Planning Inspectorate

Our Ref: EN020027

Application by National Grid Electricity Transmission (NGET) for an order granting development consent for the Norwich to Tilbury project

Advice following issue of decision to accept the application for examination

ES Volume 6 Chapter 11 Historic Environment (6.11) and Figure 11.4 Geophysical survey and archaeological trial trenching priority areas (6.11.F4)

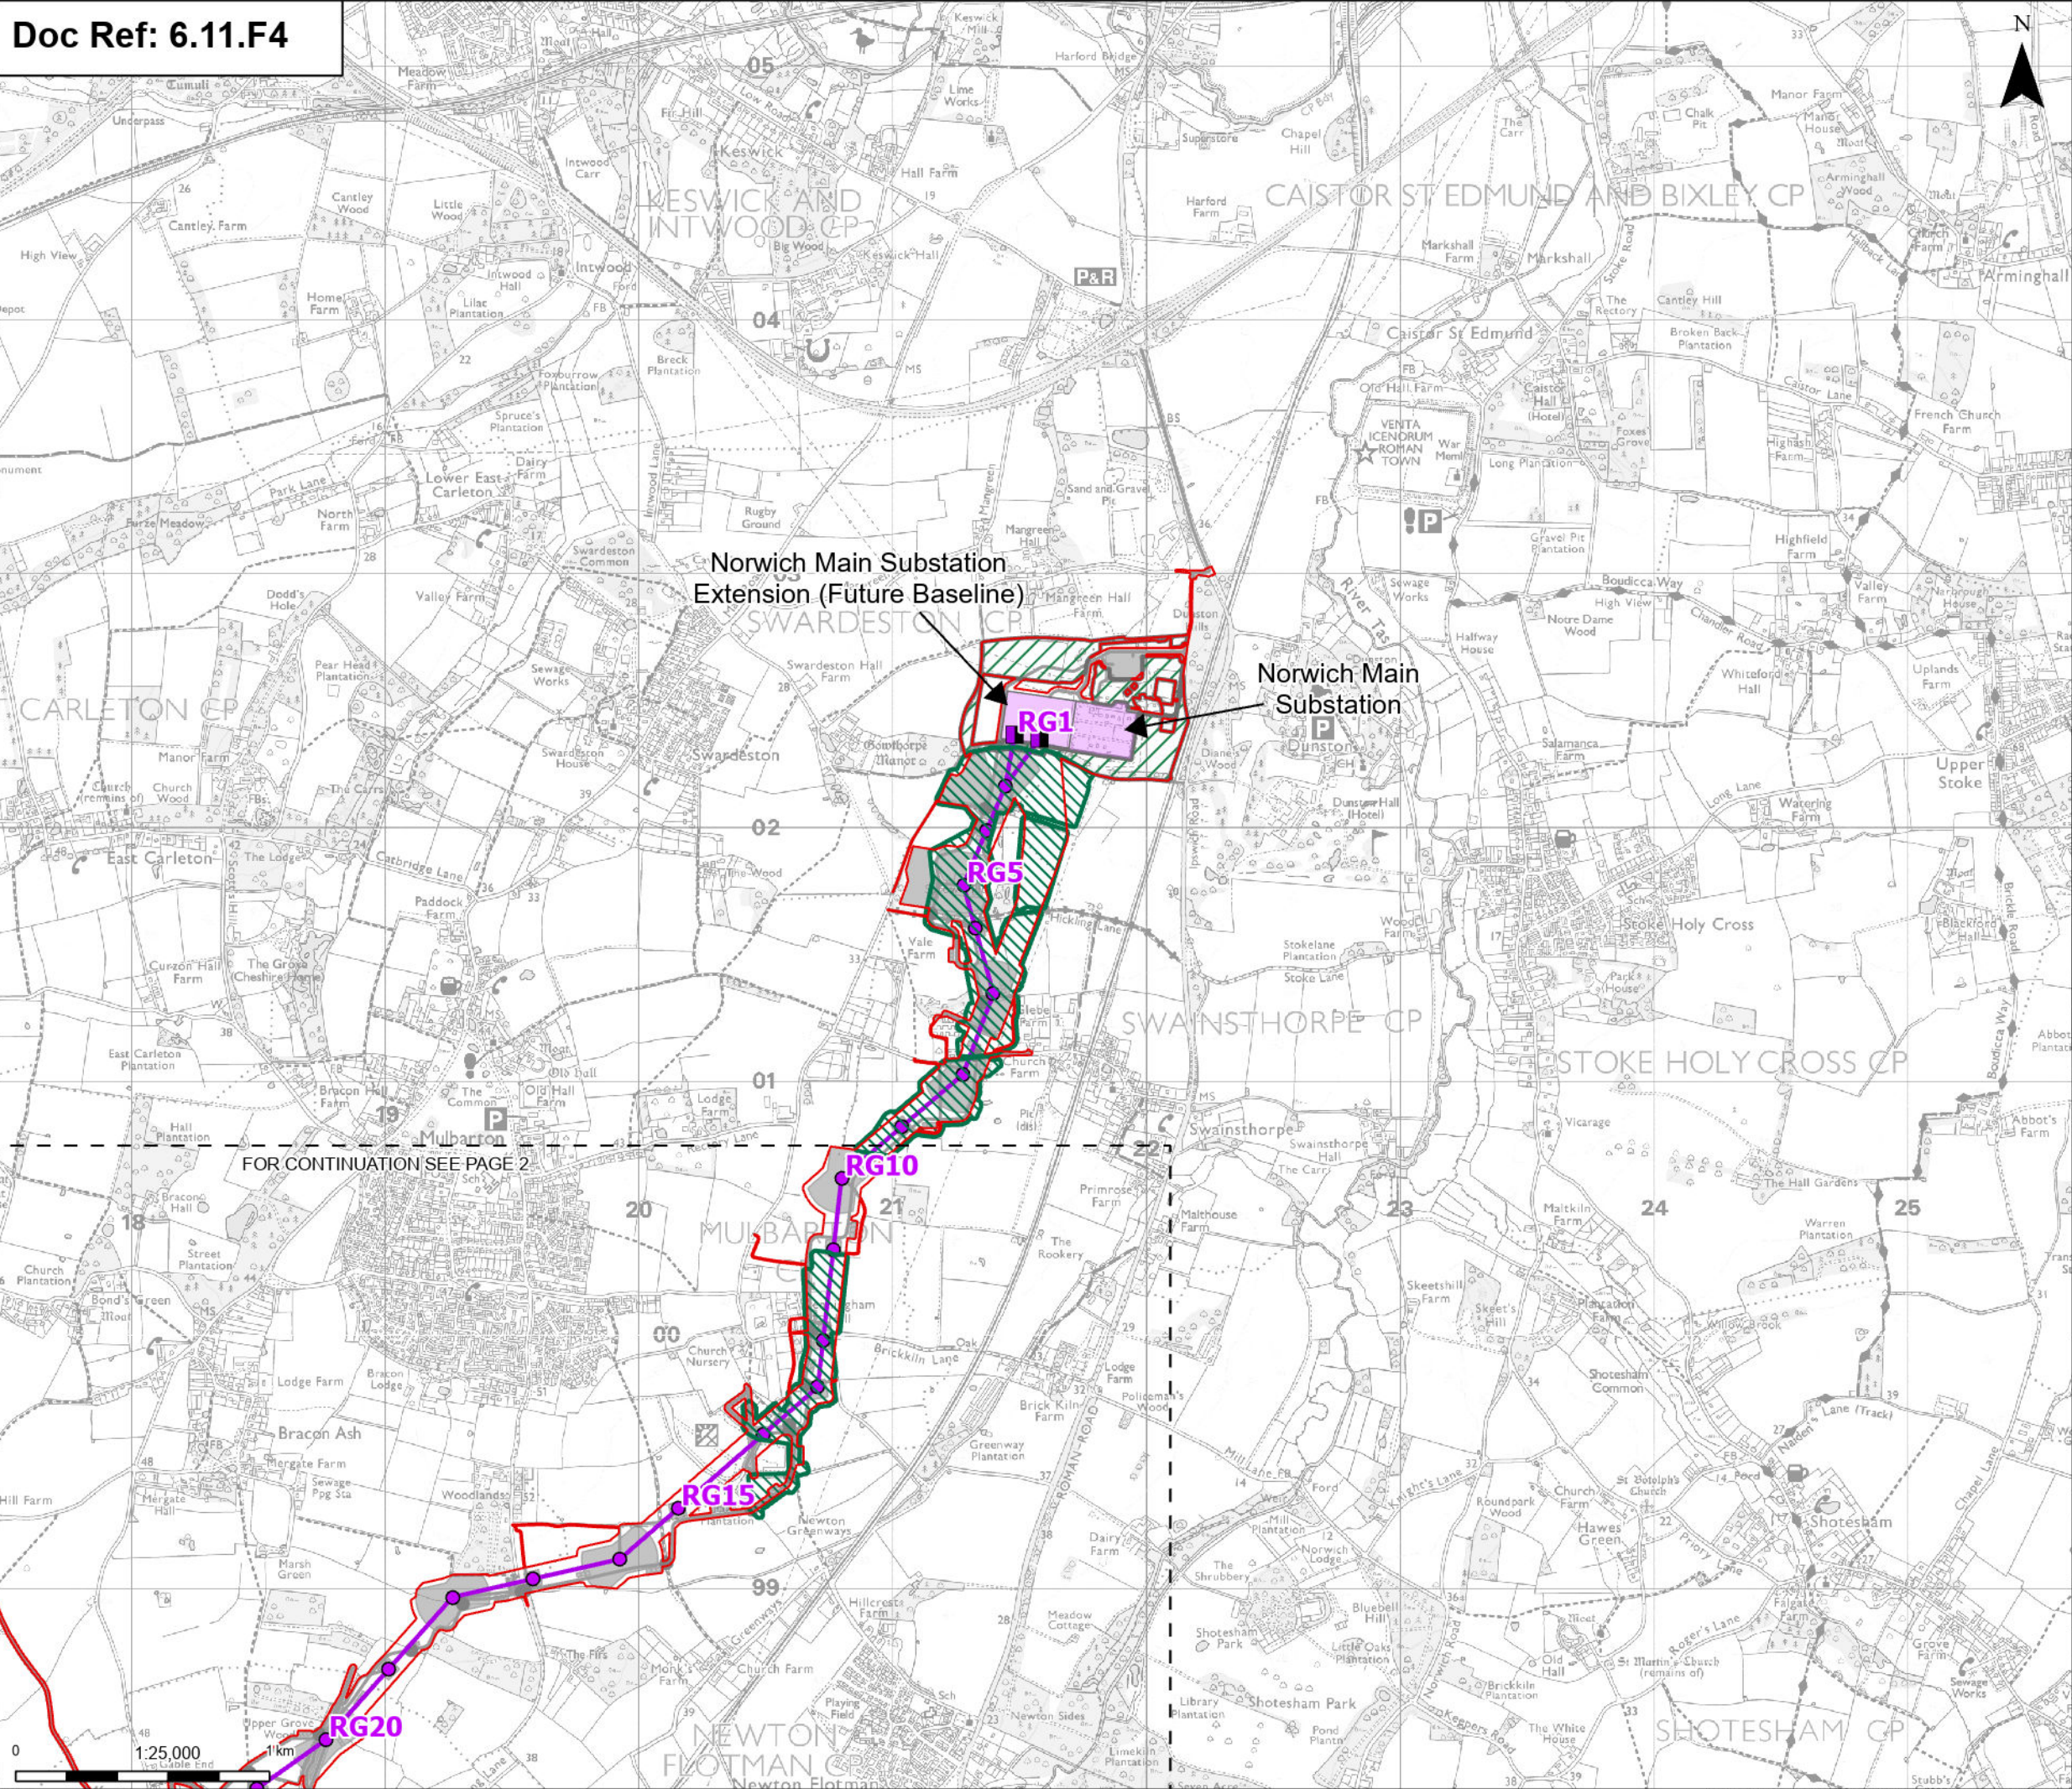
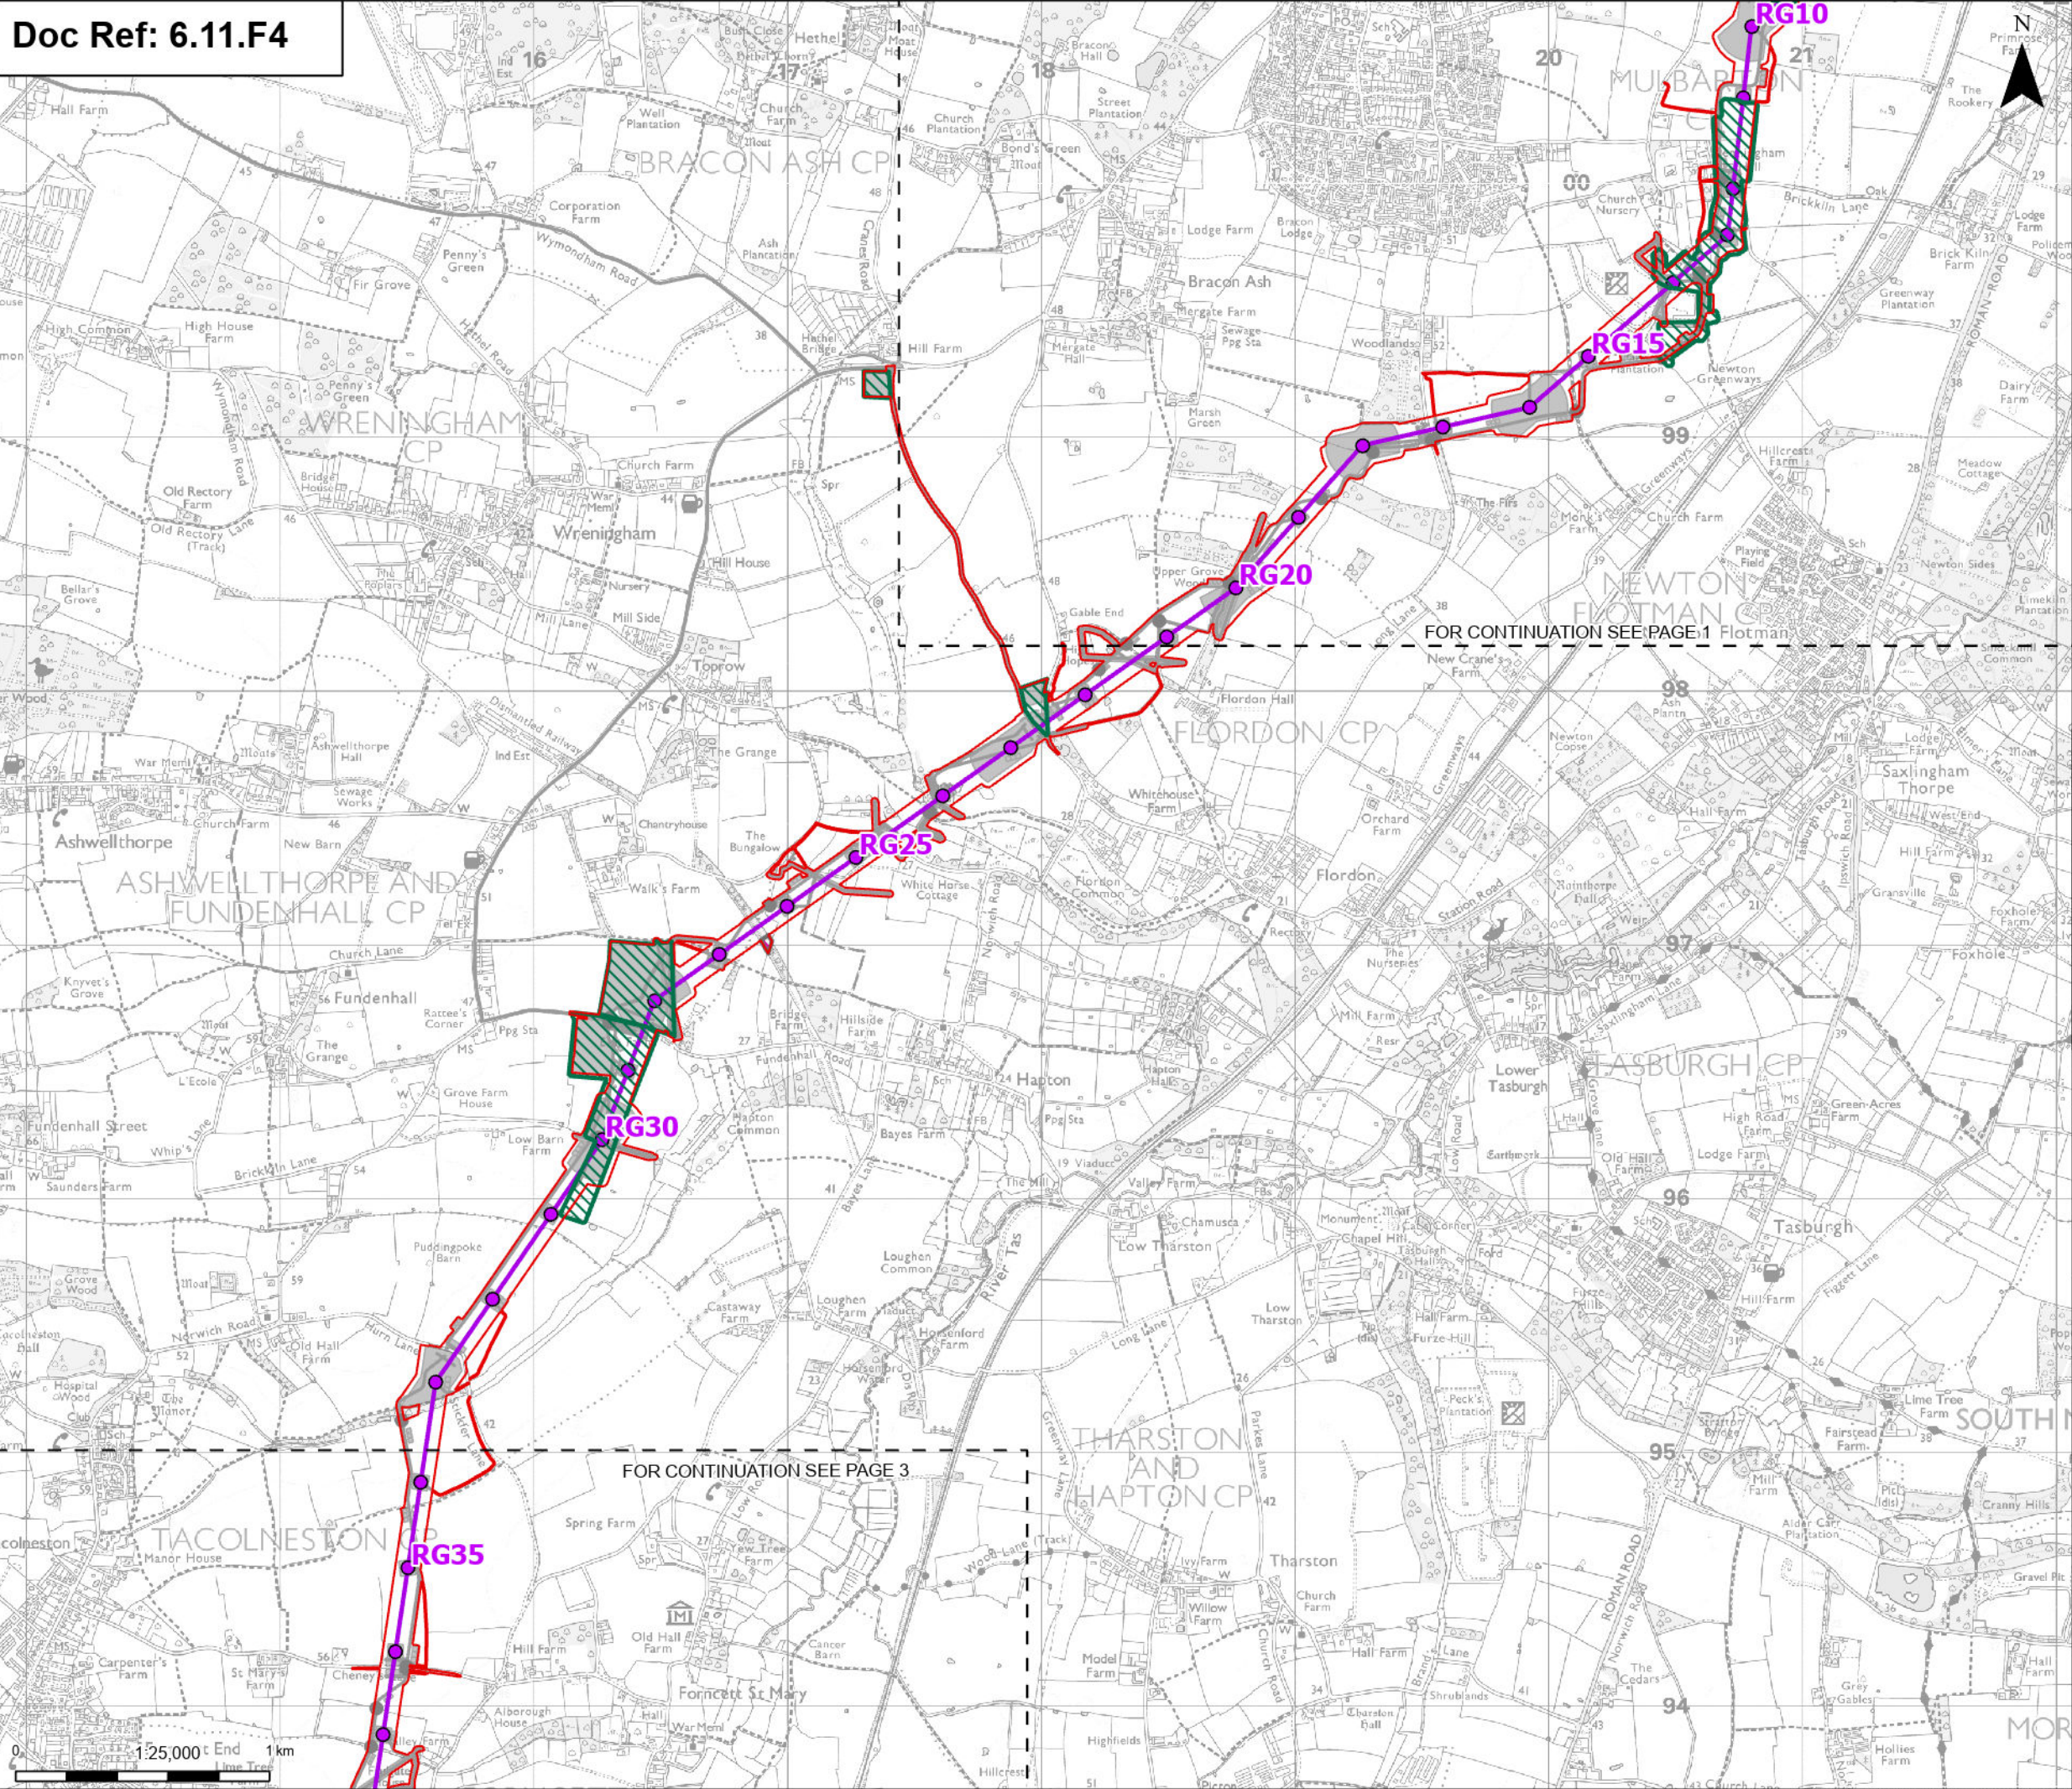
The pre-application engagement with Historic England and the relevant Councils since November 2023 regarding archaeological evaluation fieldwork is noted by the Planning Inspectorate, including the agreement of certain areas as ‘priority areas’ where geophysical surveys commenced in summer 2023 and trial trenching since Autumn 2024. The results of this fieldwork are contained within Appendices 11.3, 11.4, and 11.5 and incorporated in Section 11.5 to inform the baseline for assessment. It is noted that archaeological work on these areas and upon ‘phase 2 areas’ is ongoing and will continue into 2026, and that this approach has been agreed with the relevant statutory bodies. Table 11.2 of chapter 11 of the ES details these works to a certain degree, with a map of priority areas included in figure 11.4. It is noted that results from these further works is programmed to be submitted at various times: November 2025 prior to the start of the Examination; shared and agreed with Stakeholders early in 2026; and throughout 2026.

The Planning Inspectorate advises the applicant provides further clarification on such works in terms of details of the nature and location of the further works, and how and when the results will be submitted (see below regarding updates to the ES). It would also be beneficial if the results and analysis were submitted together where possible to avoid the drip feeding of information.
